Our Ref: FG/102/18/HH
Your Ref:

Town & Country Planning Act 1990 (as amended)
Town & country Planning (Development Management Procedure) (England) Order 2015
Application for Planning Permission for Works or Extension to a Dwelling

Development Two storey rear extension & single storey side extension for new garage.
Location 29 Beehive Lane Ferring

Ground floor

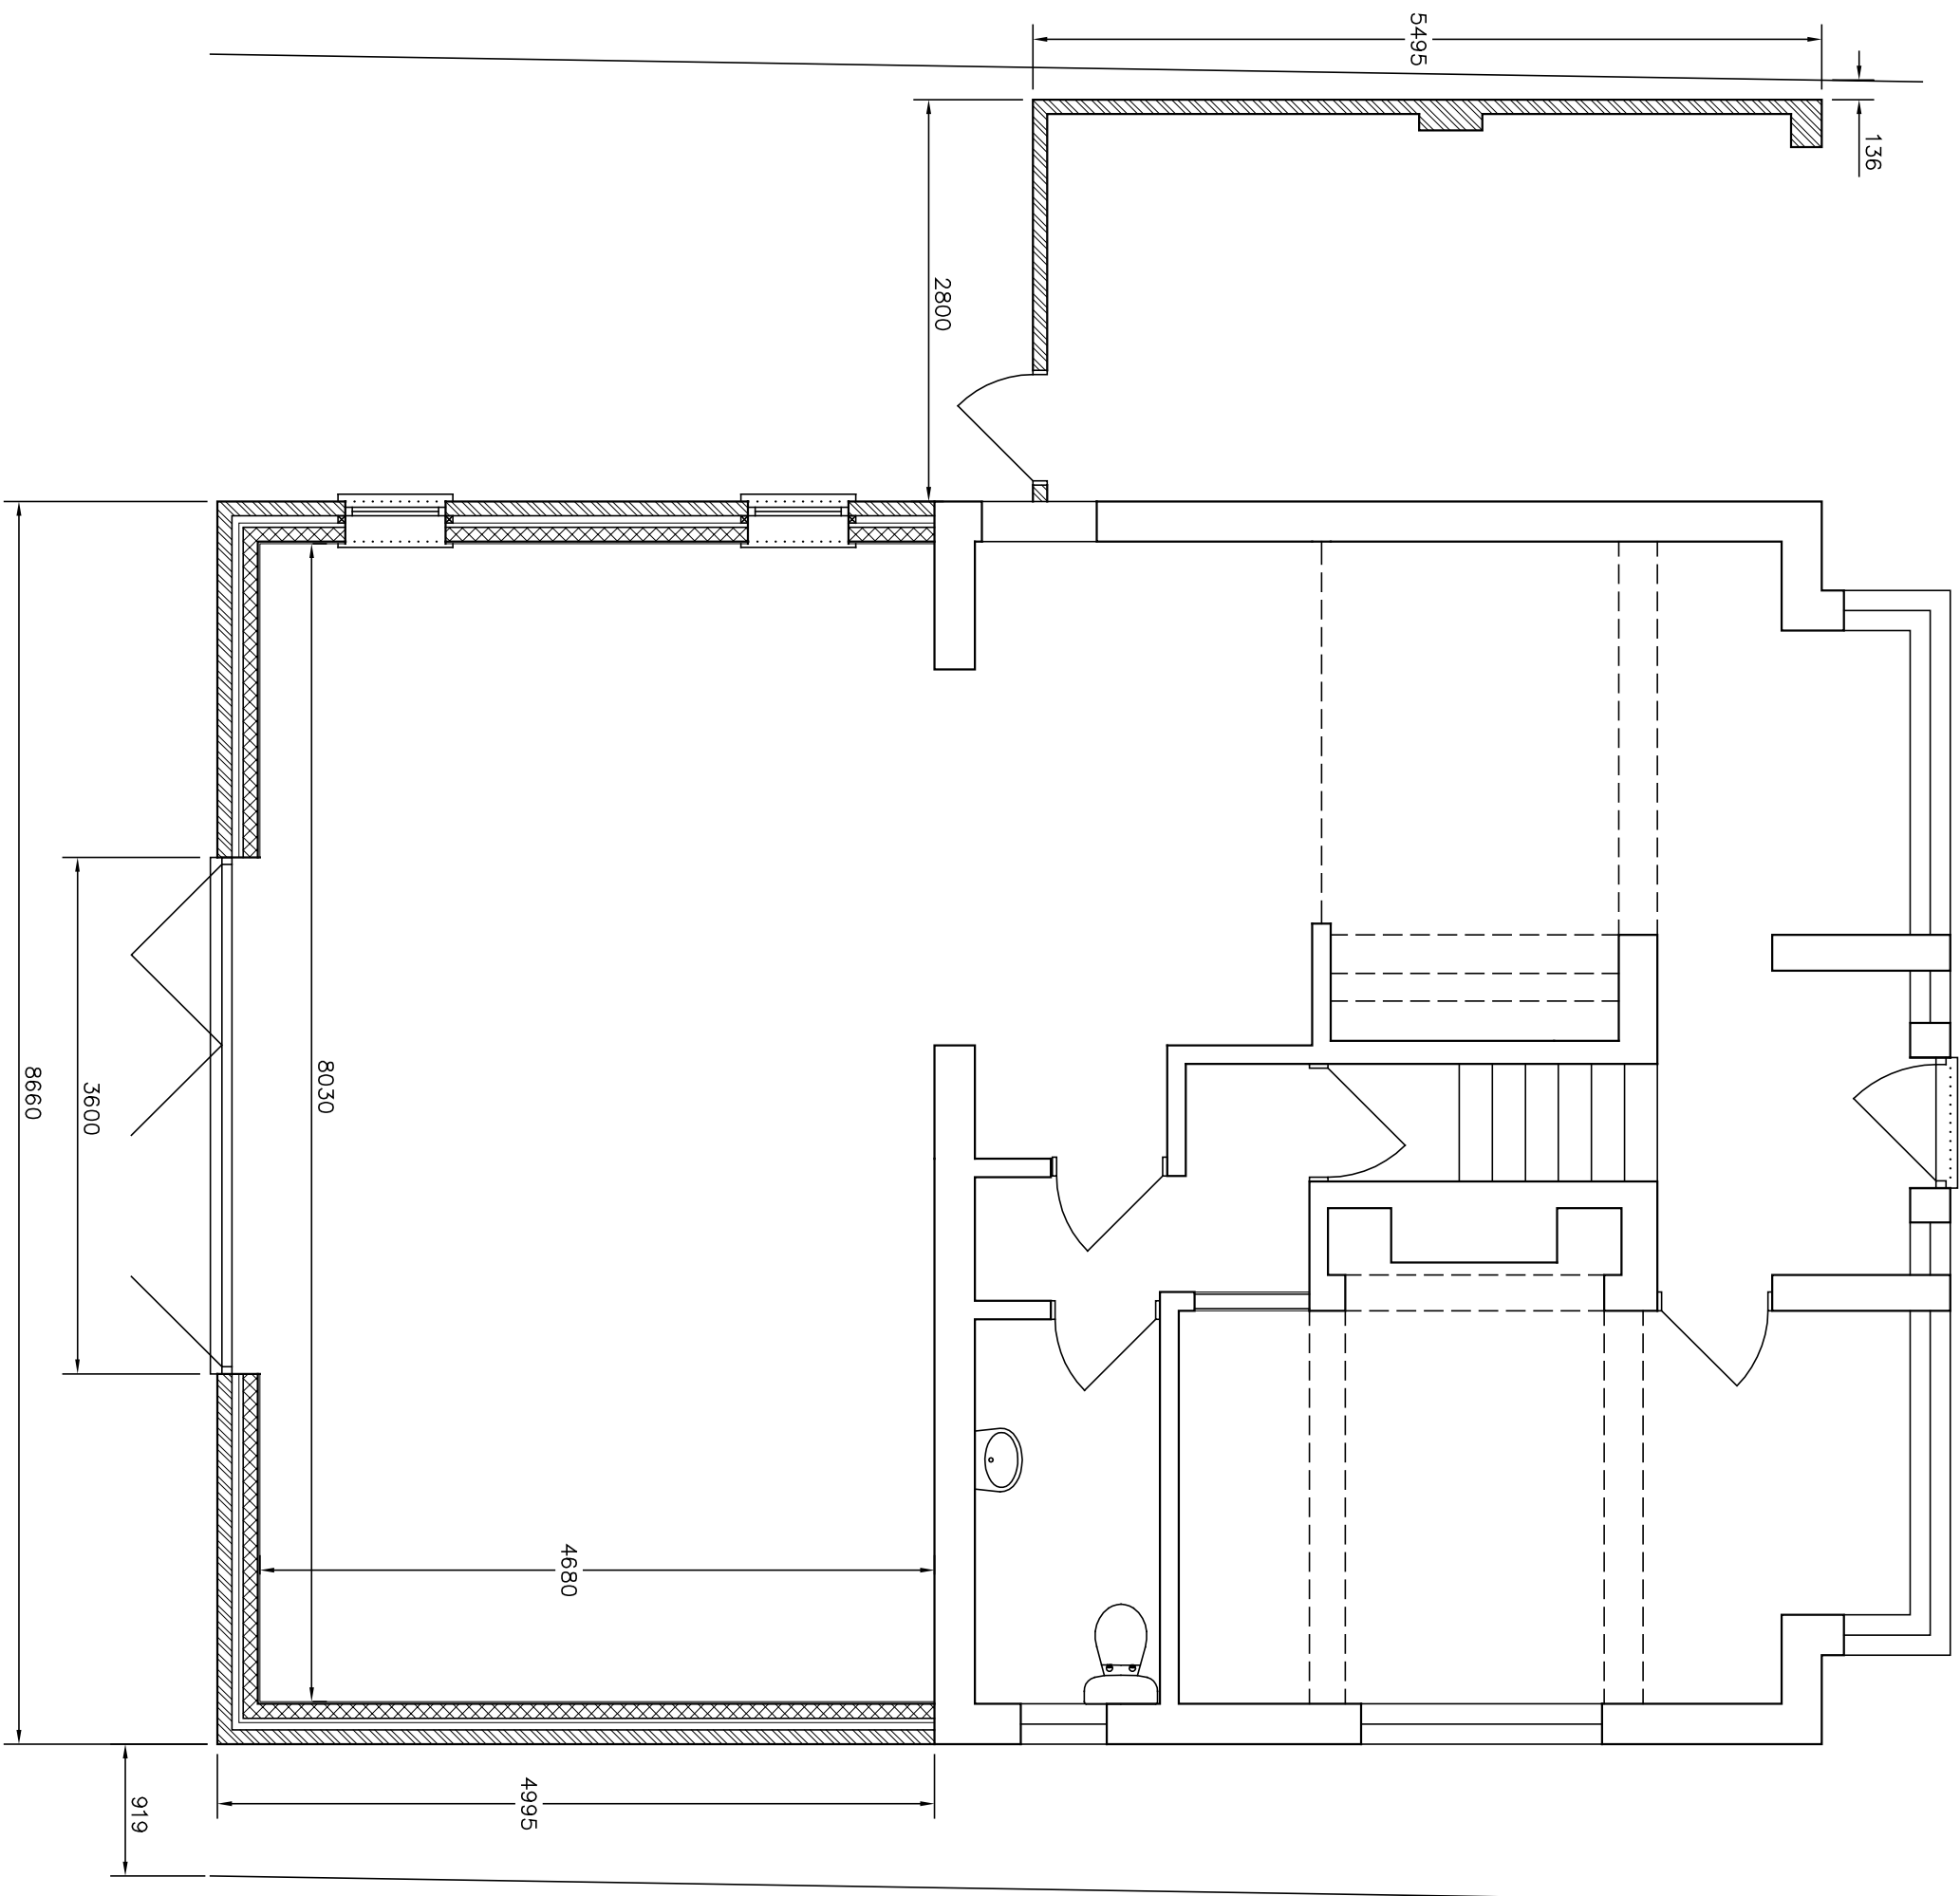
The existing and proposed ground floor plan and west elevations do not accord. Please amend accordingly.
